CPP Project 4946

Project: Block 2 - Frasers Broadway

Further to meeting with PTW yesterday and their provision of revised drawings, please find herein clarification of the wind conditions in and around the proposed development.

PODIUM AWNING DETAILS SHEET

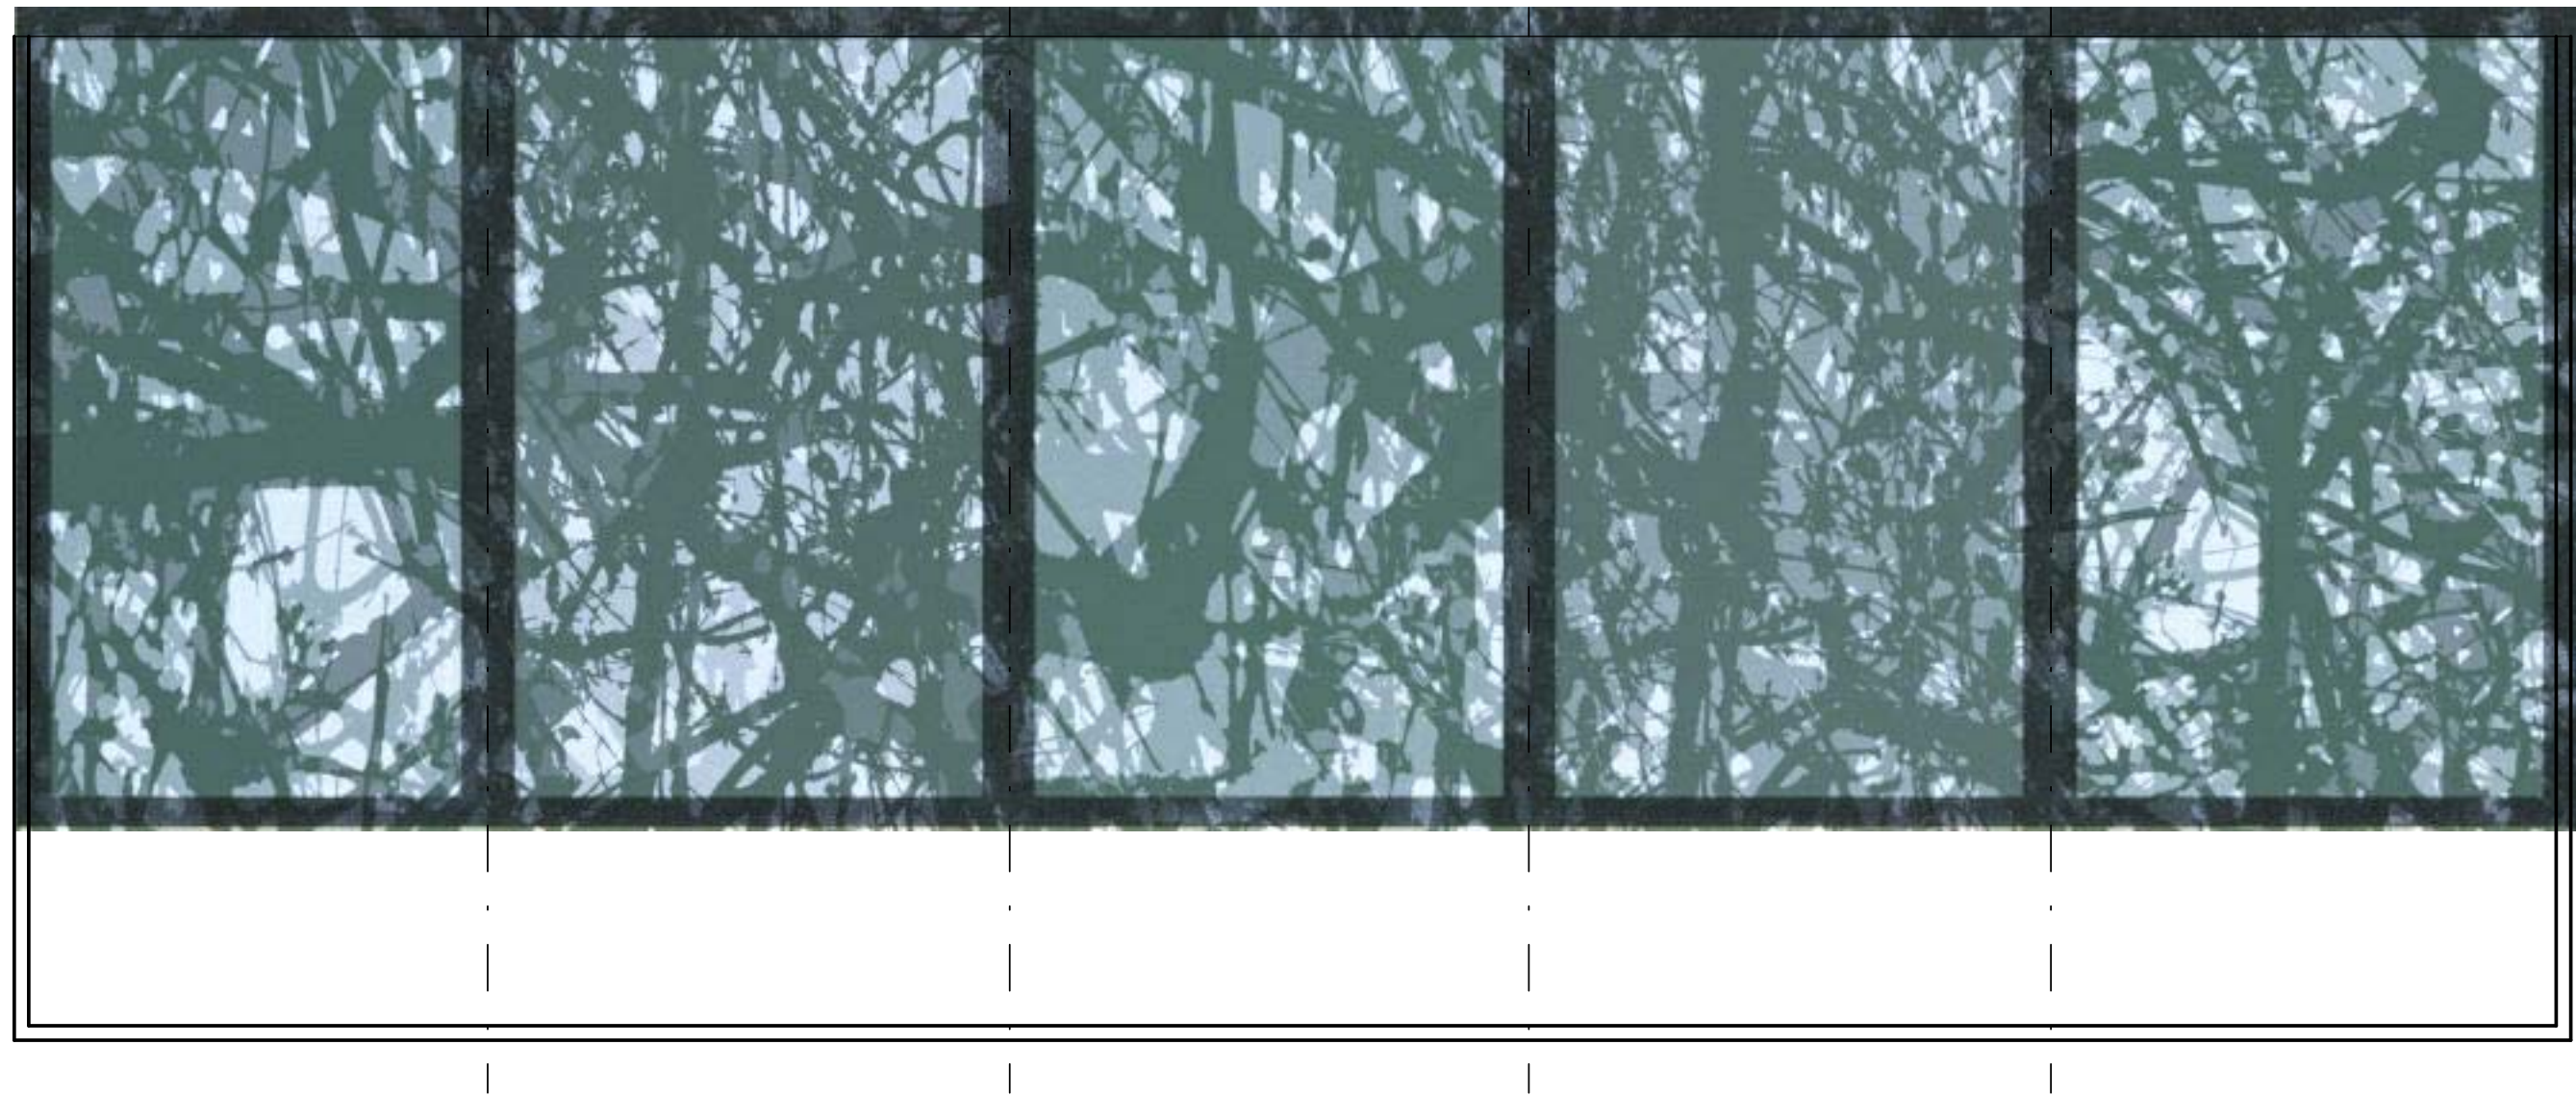
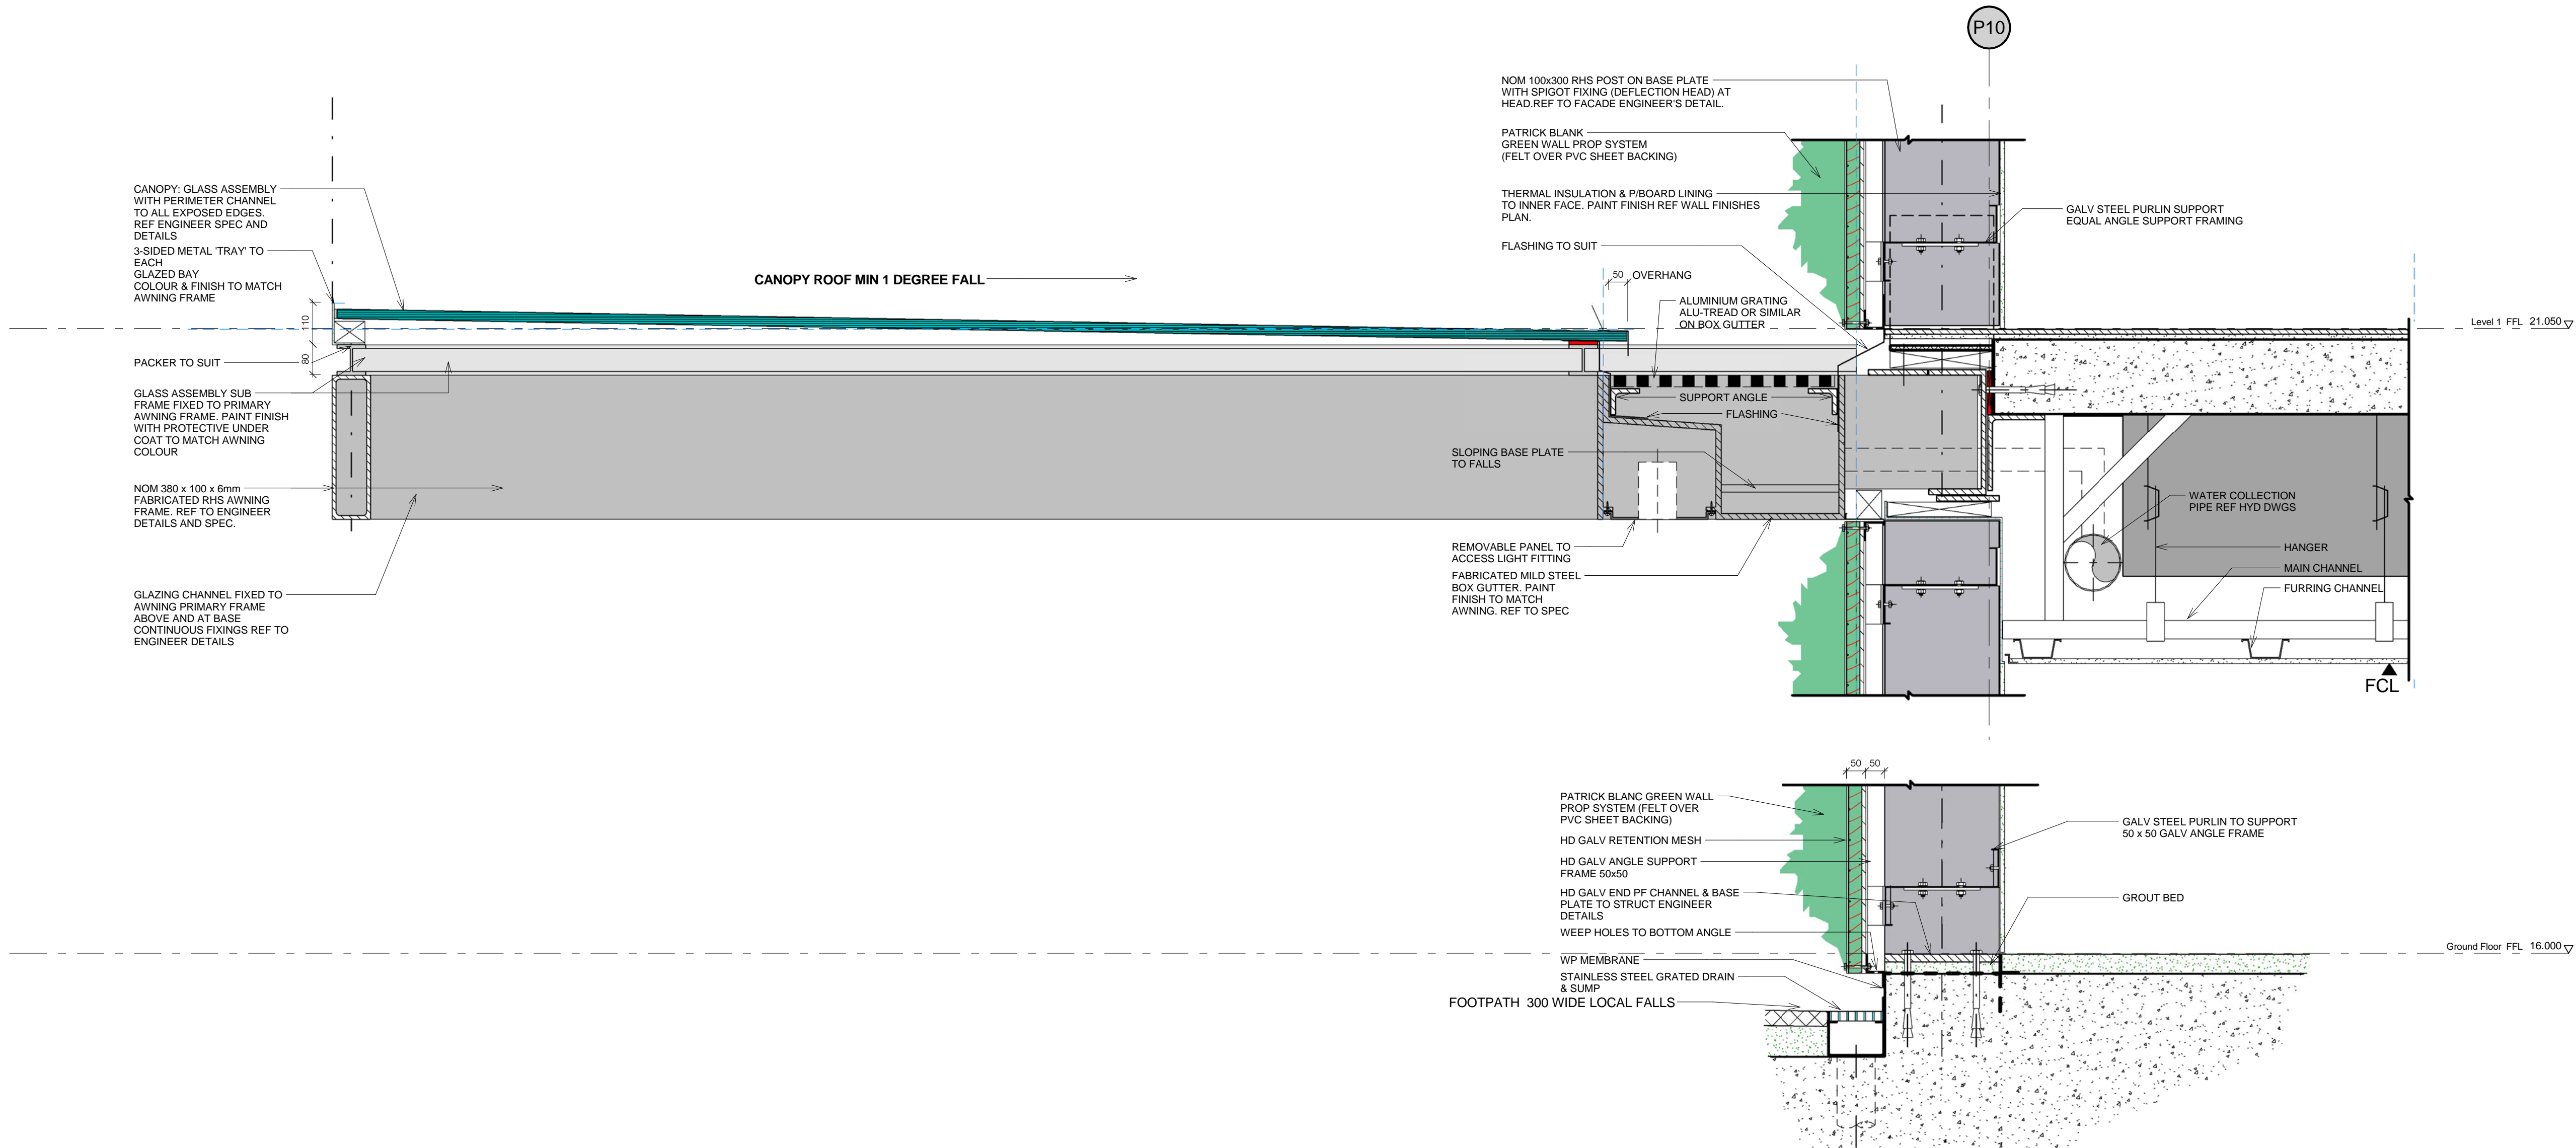
The wind tunnel testing illustrated that the only unacceptable location was around the corner of Broadway and Kent Road, next to the existing heritage gate. This is caused by downwash from the eastern façade accelerating down and around the north-east corner for winds from the easterly quadrant. Recommendations to improve wind conditions by wrapping the Broadway awning into Kent Road have been adopted. This amendment has been shown via wind tunnel testing to significantly improve the wind conditions in this area.

This amendment satisfactorily addresses the only pedestrian level wind issue around the development site.
